KIRKLEES METROPOLITAN COUNCIL INVESTMENT & REGENERATION SERVICE

DELEGATED DECISION TO DETERMINE PLANNING APPLICATIONS

Reference No:	2023/62/92610/E
Site Address:	22, Gib Lane, Skelmanthorpe, Huddersfield, HD8 9BG
Description:	Demolition of conservatory style additions, erection of two storey side and single-storey front extensions and detached garage
Recommending Officer:	Jennifer Booth

OFFICER REPORT

Client Mr & Mrs Kaye
Project 2409 : 22 Gls Lane : Domestic Extension
Title Proposed Garage Plans and Elevations
-

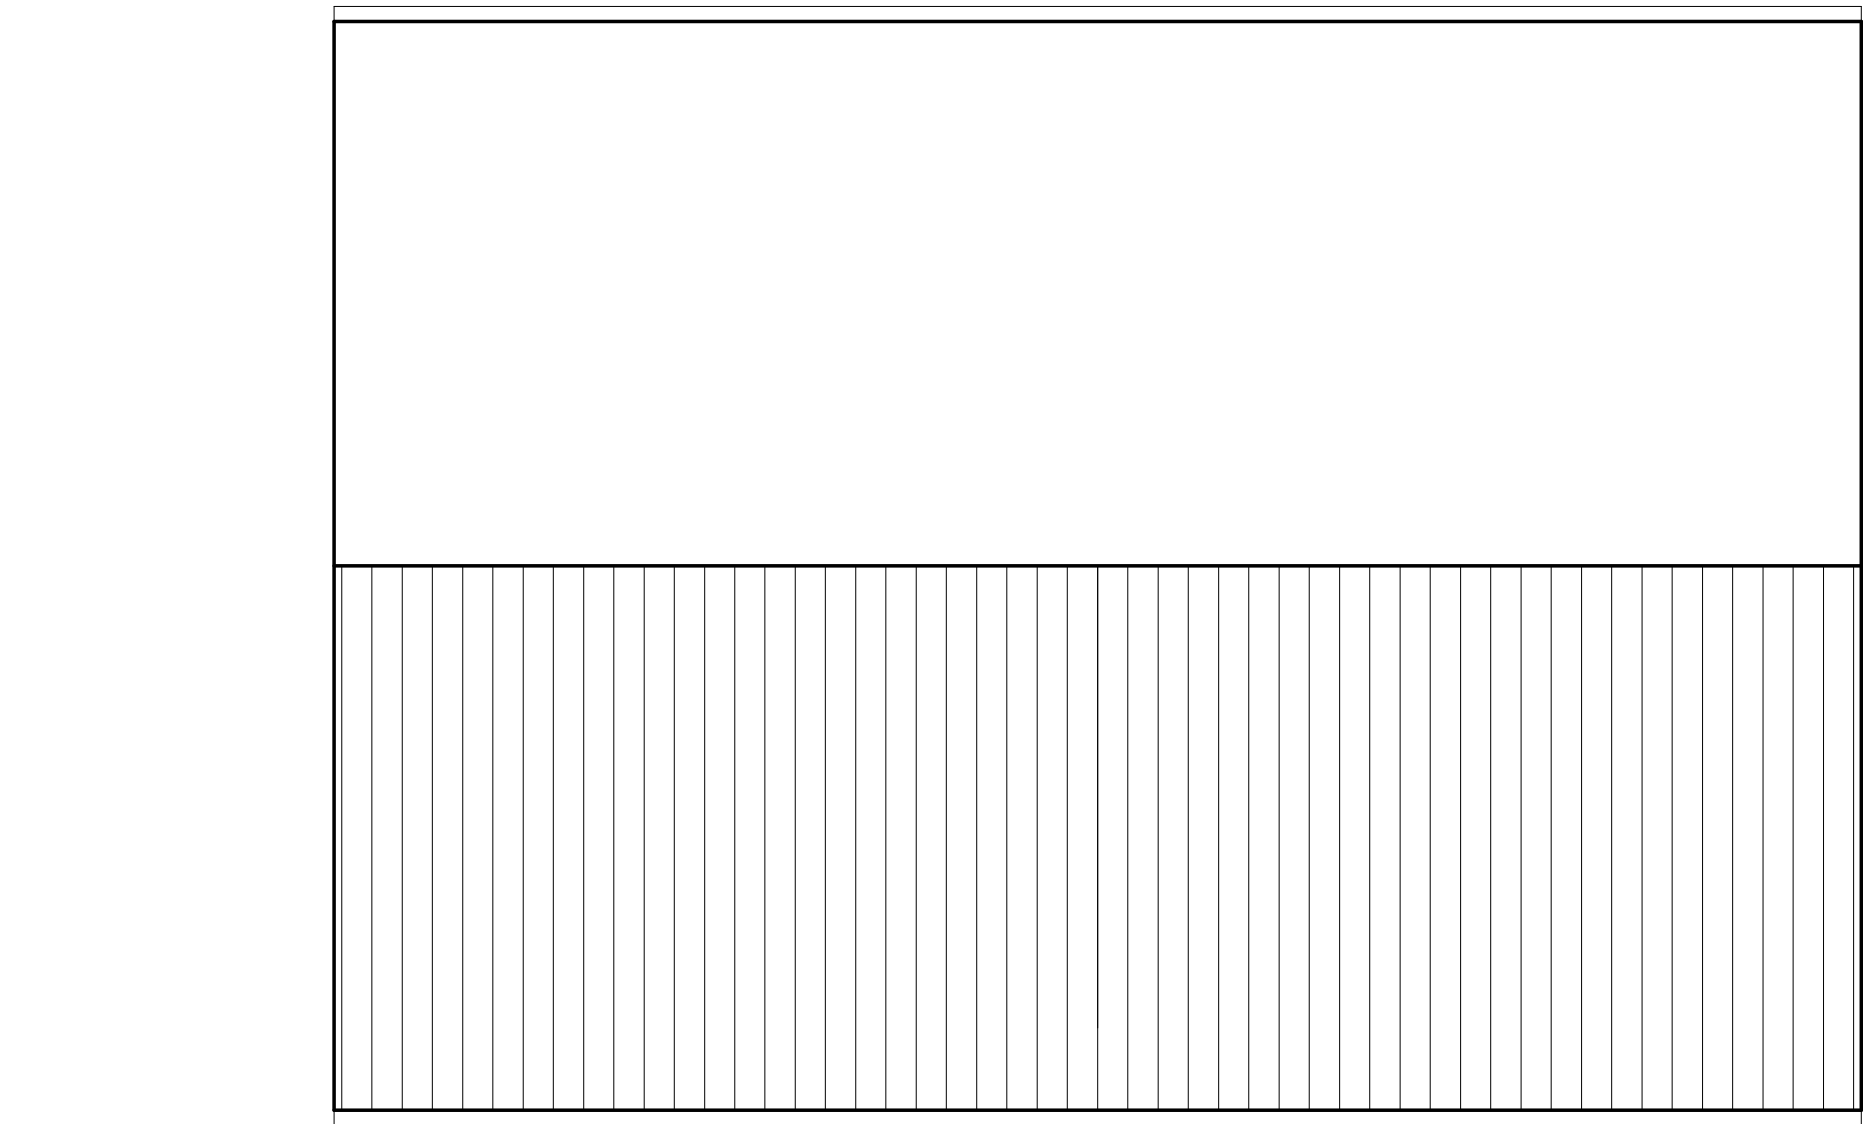
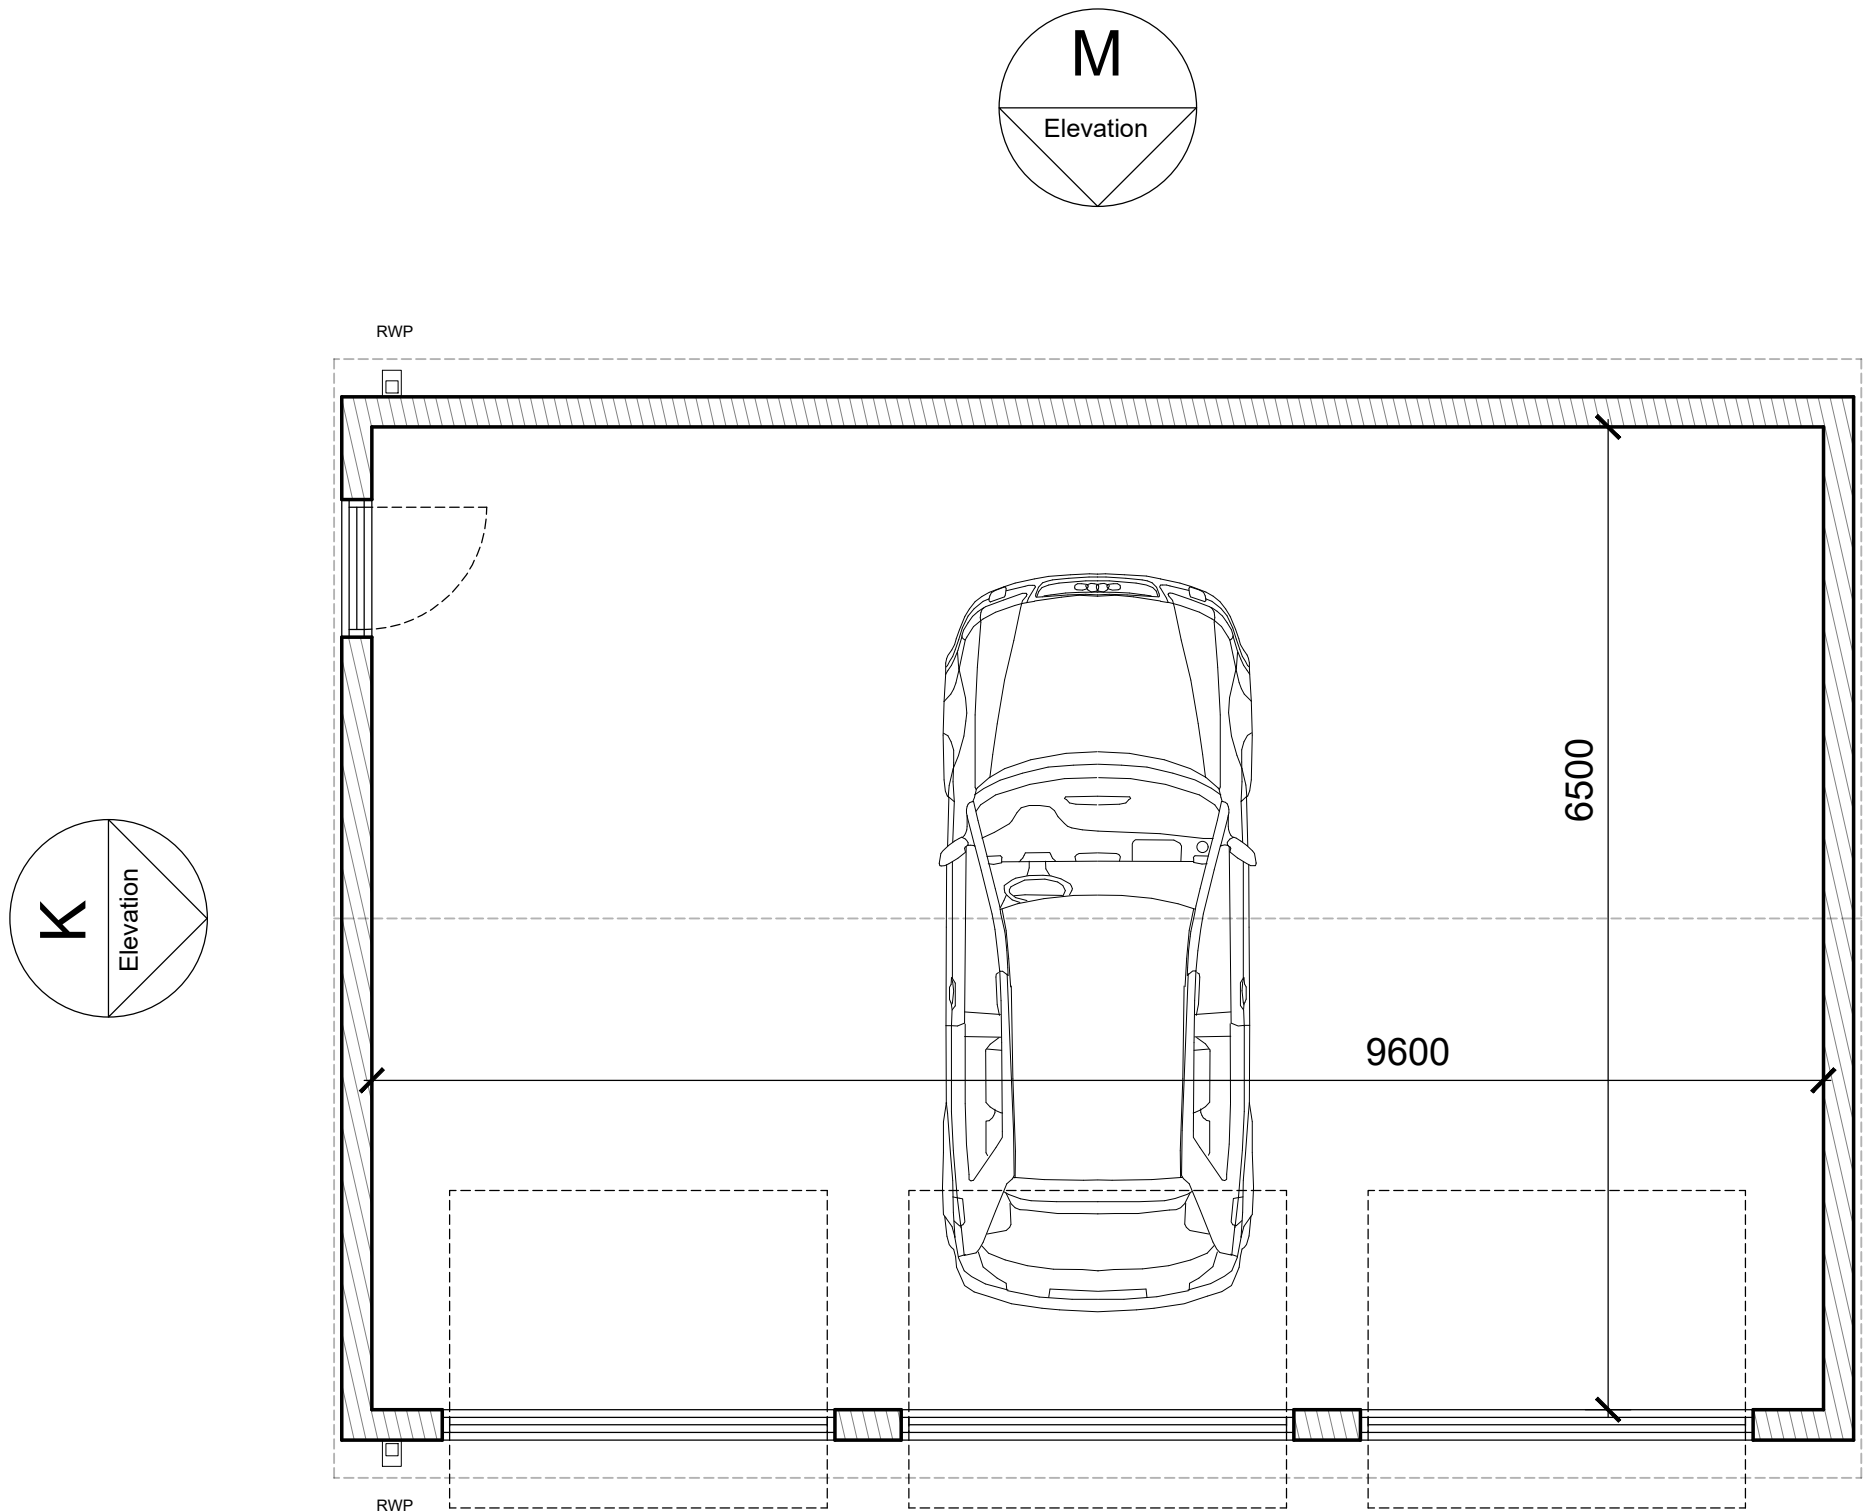
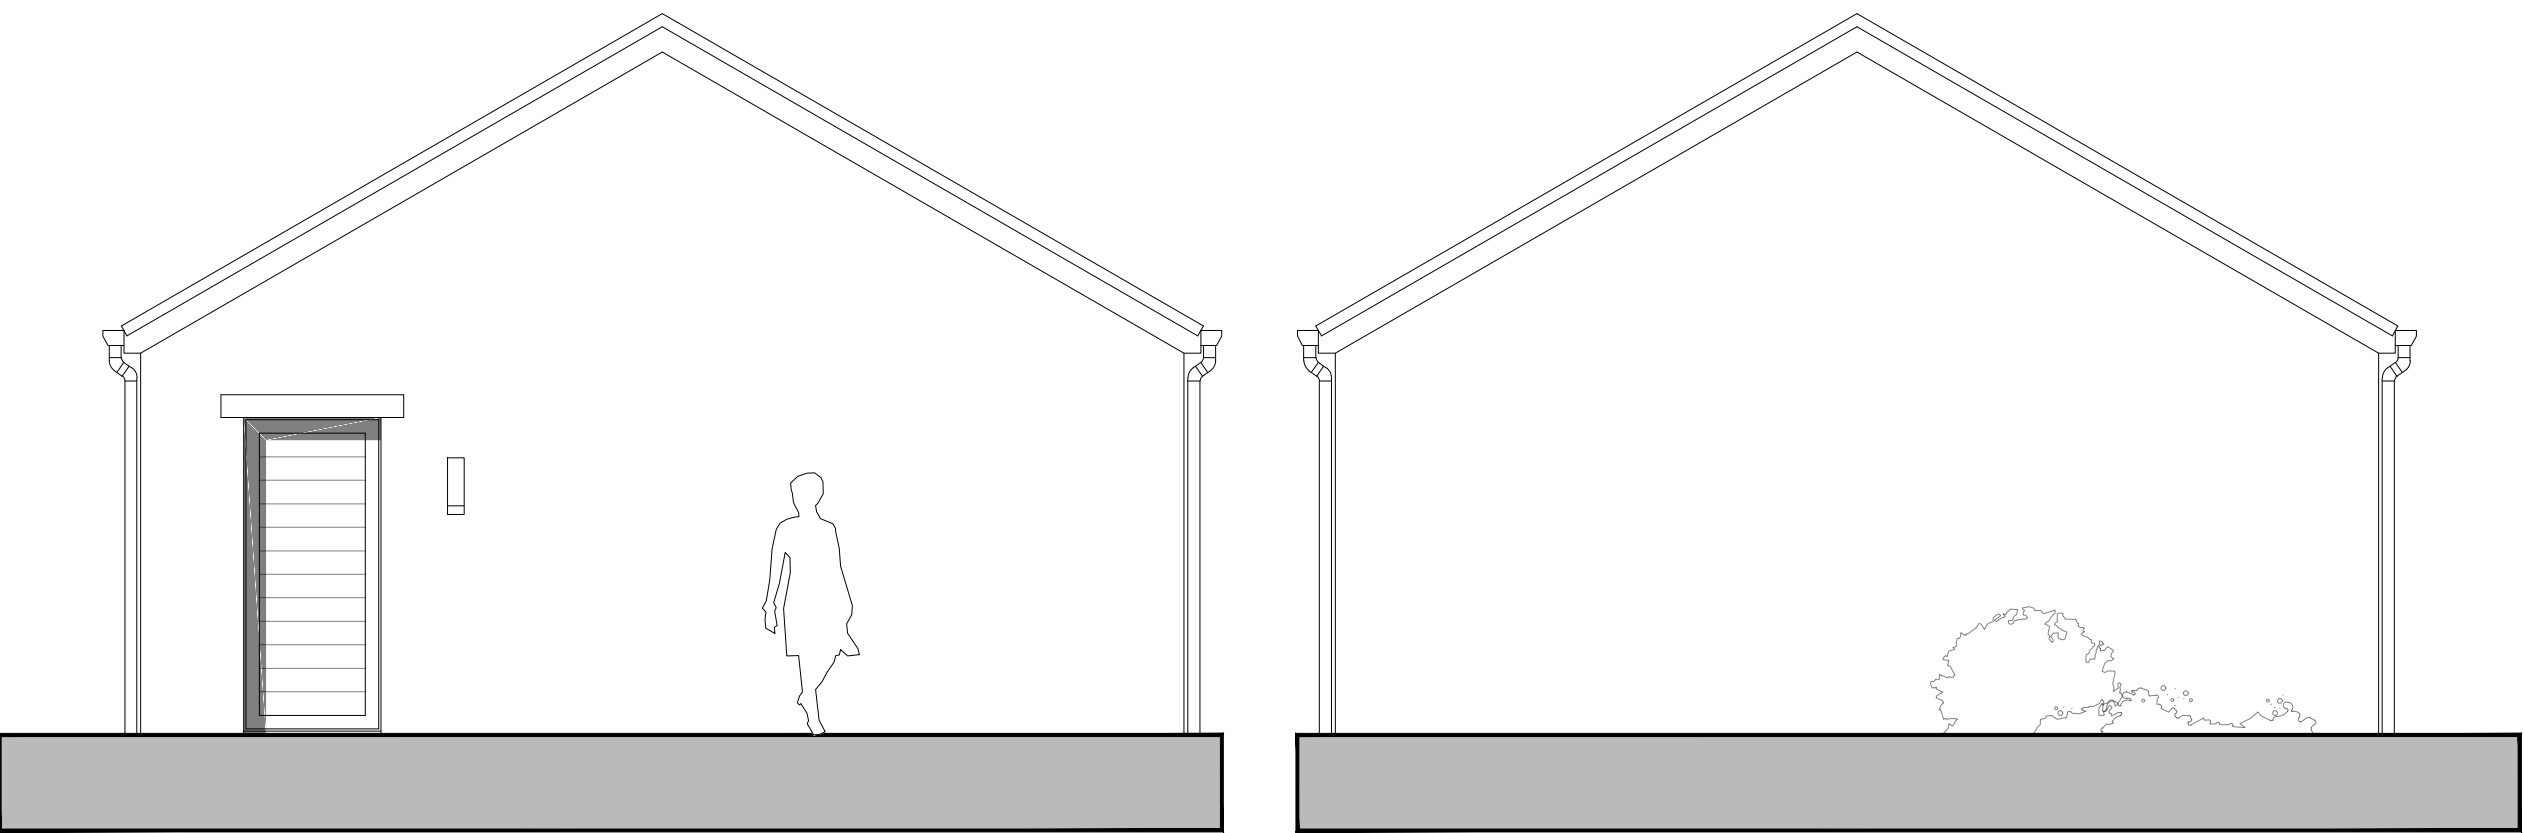
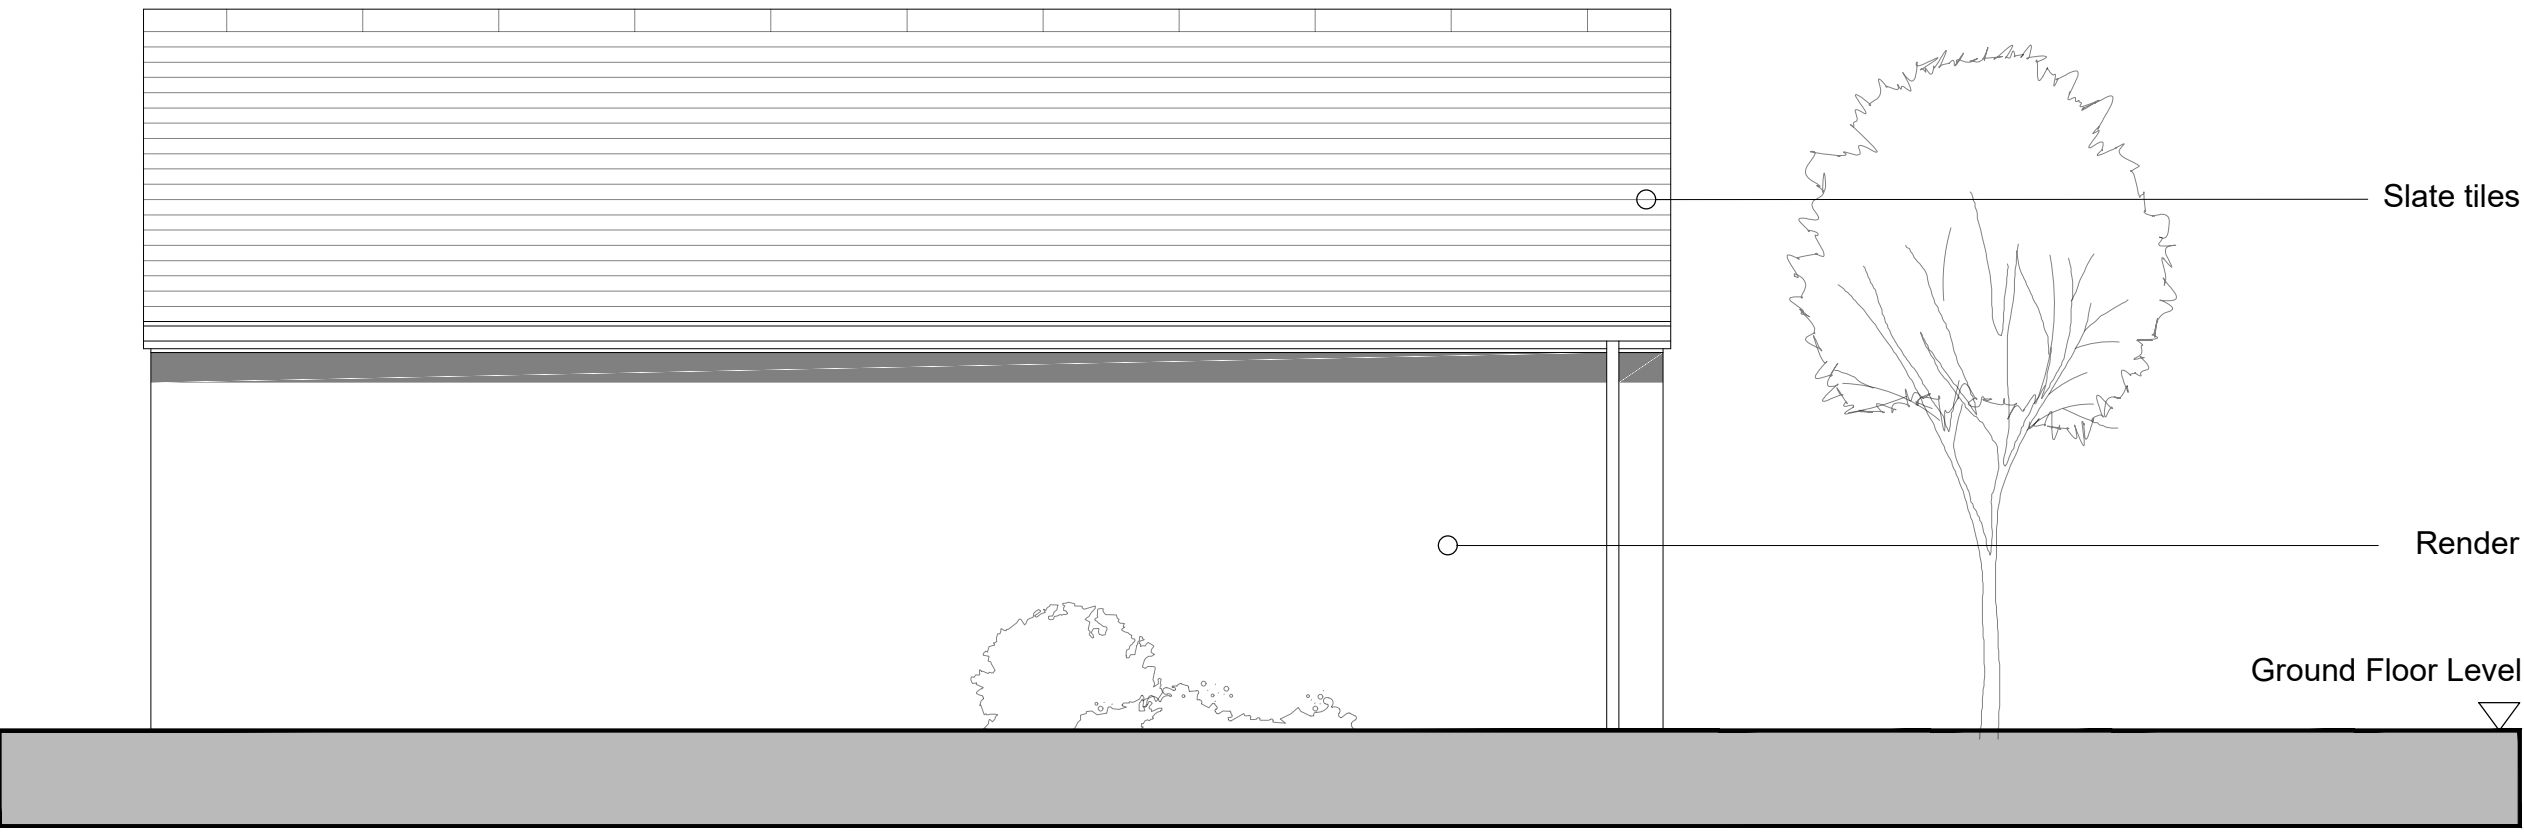
agents/applicants, this is only within the scope of the application under consideration. The initially submitted plans raised concerns in terms of the height of the outbuilding. Amended plans have been received which reduced the height. As the alteration reduced the scale, the amended plans have not been advertised.

The proposed outbuilding would be close to the shared boundary with the neighbouring property to the south west. However, the structure is single storey with an eaves height of 2.5m which should fall below the boundary fence with a pitched roof form which would take the vertical emphasis up and away from the neighbour. Given the spatial relationship there would be no significant overbearing, overshadowing or overlooking.

The initially submitted plans raised concerns in terms of the height of the detached garage outbuilding. Amended plans have been received which reduced the height. As the alteration reduced the scale, the amended plans were not advertised.
